WEST SUSSEX COUNTY COUNCIL CONSULTATION

TO:	Arun District Council FAO: Katie Sharp
FROM:	Stephen Gee WSCC - Highways Authority
DATE:	12 May 2022
LOCATION:	Land off Arundel Road Angmering
SUBJECT:	A/270/21/OUT Amendments received on 11th April 'Hybrid application comprising: a) Demolition of existing buildings; b) Full planning application for the development of 160 No. dwellings with open space, landscaping and sustainable drainage systems (SuDS), and two vehicular access points from Arundel Road; c) Outline application with all matters reserved except for up to 1,393 square metres of Class E floor-space with associated parking provision and 2.1 hectares of sports pitch land.' This site is a Departure from the Development Plan Hybrid application comprising: Full planning application for the development of 160 No dwellings with open space, landscaping and sustainable drainage systems (SuDs), and two vehicular access points from Arundel Road; Outline Application with all matters reserved except access for up to 1,393 sqm of Class E floorspace with associated parking provision. This site is a Departure from the Development Plan and affects the setting of listed buildings.

Commercial Access General Arrangement (1:1000)

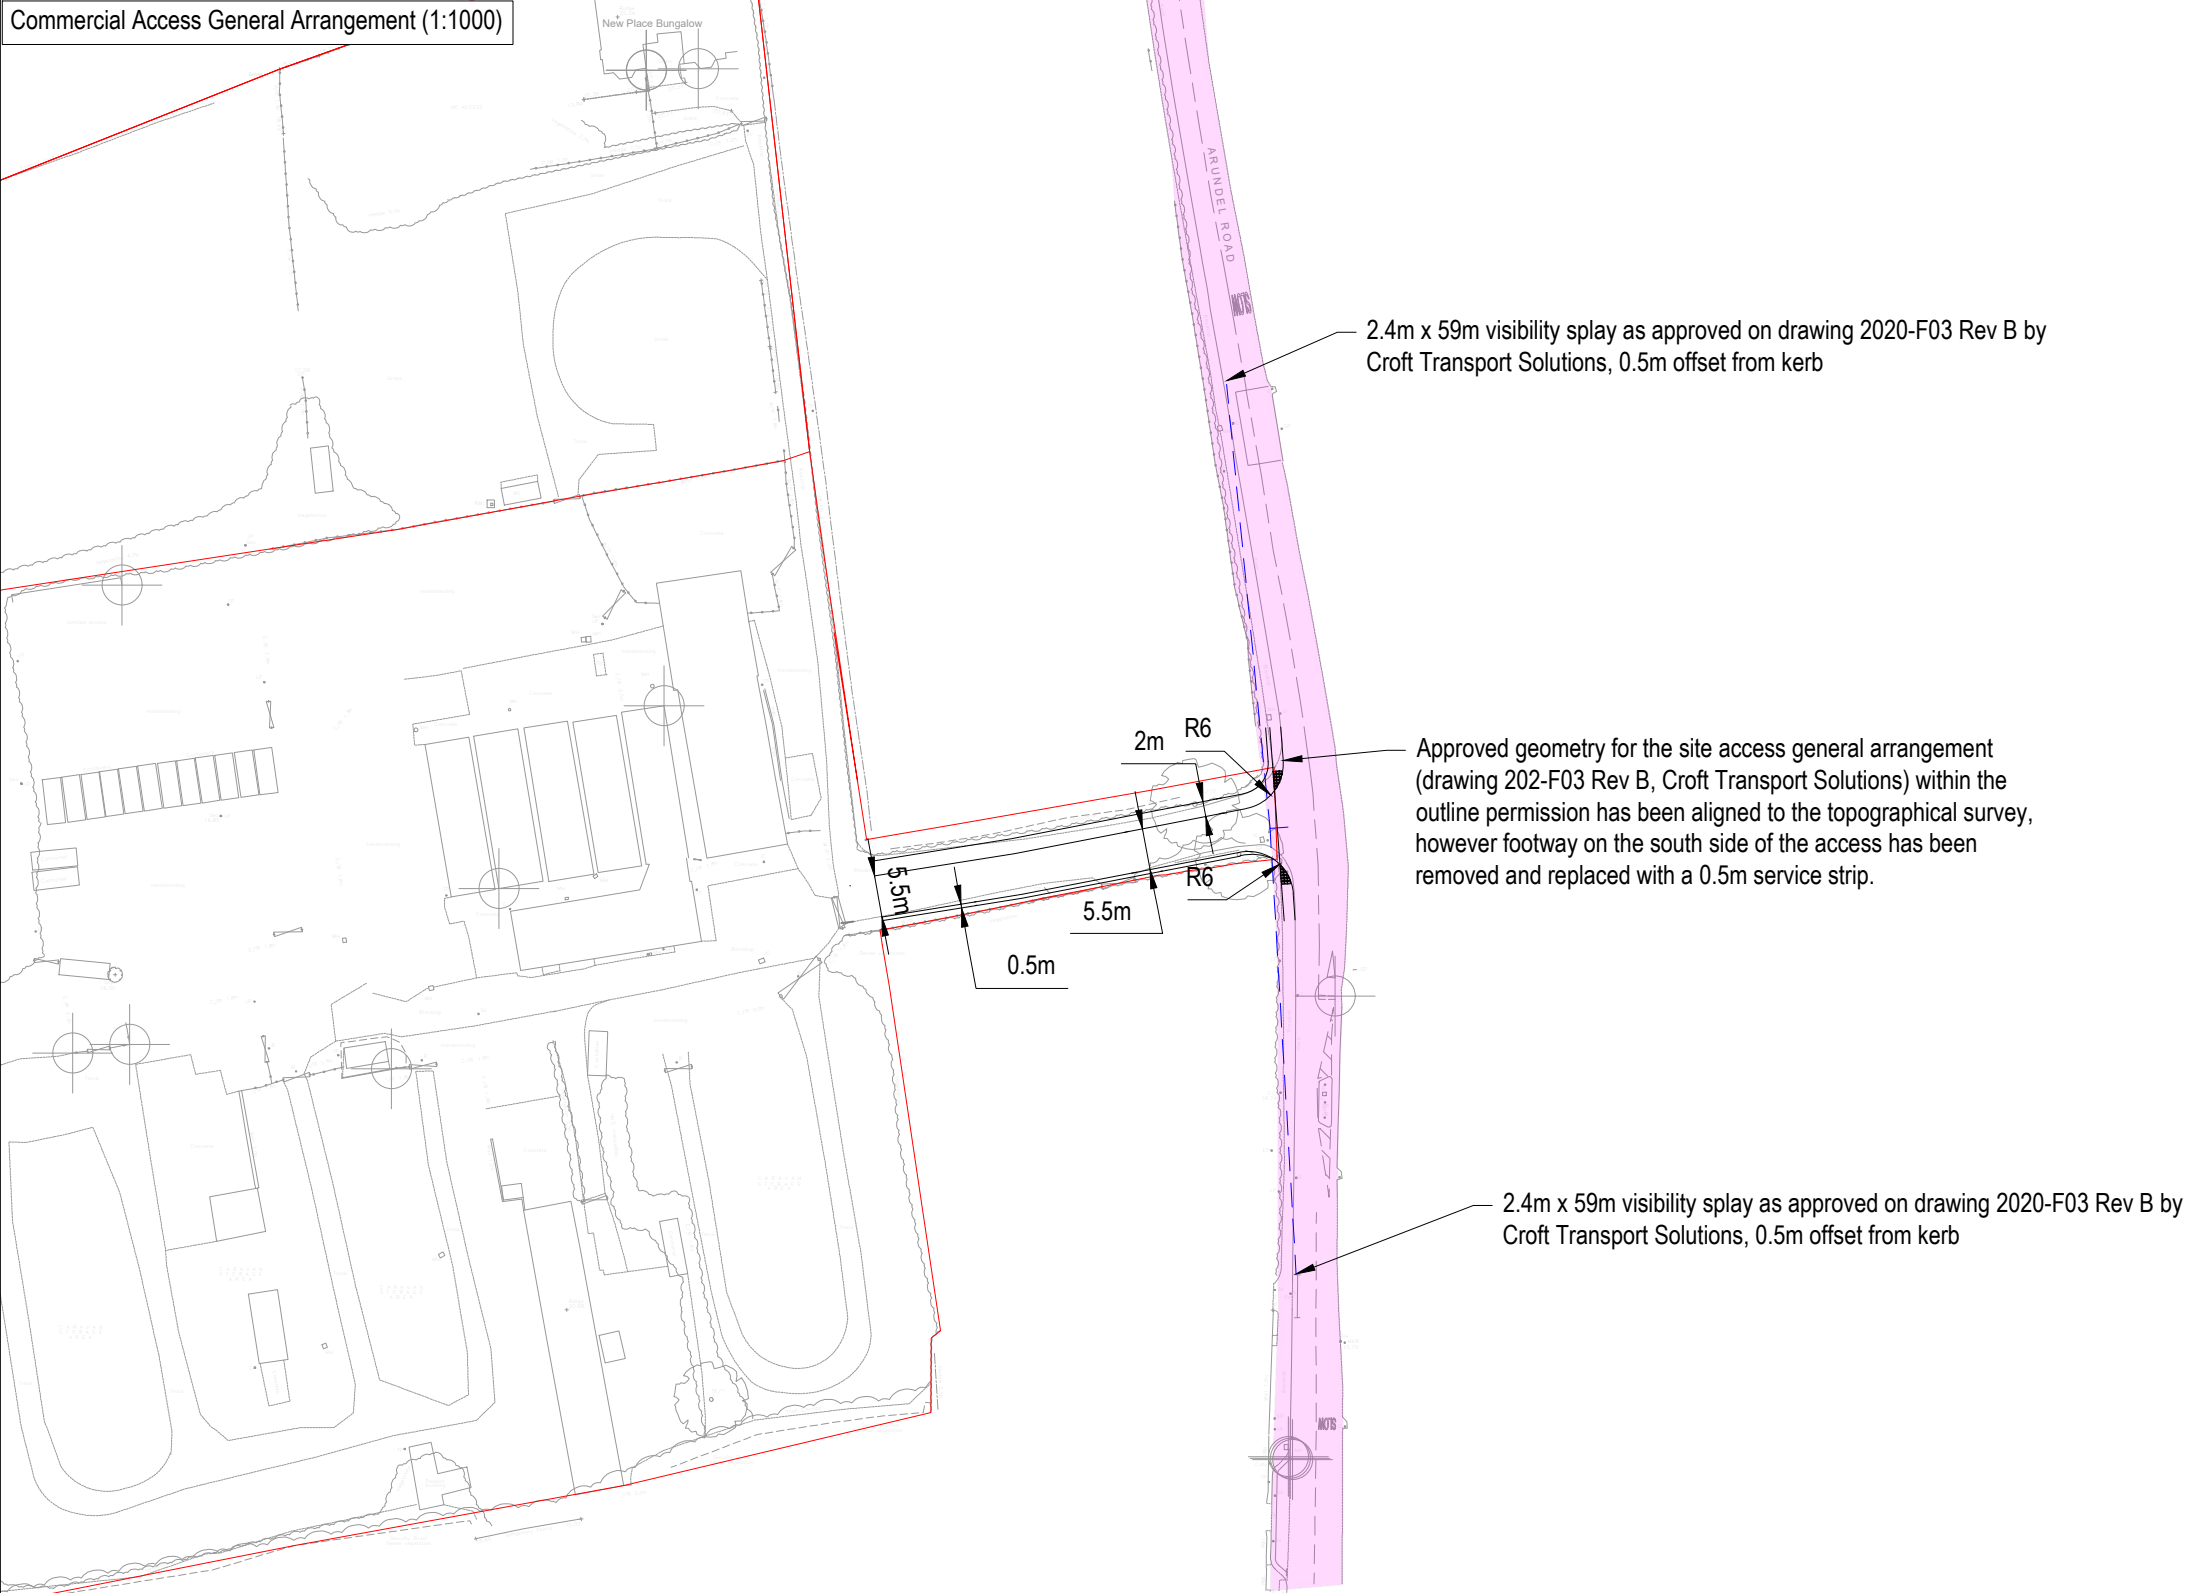
The northern access would serve the residential element and southern the commercial (an upgrade of the existing access) as per my comments on the RM and replicated below routes internal of the development should be made for pedestrians and cyclists to utilise.

No vehicular access is possible between the northern and southern accesses internal of the site. The scheme may benefit from an emergency access link should either become blocked.

No details are shown as to how a pedestrian and cycle connection could be made to allow the residential element of the development to utilise the southern access
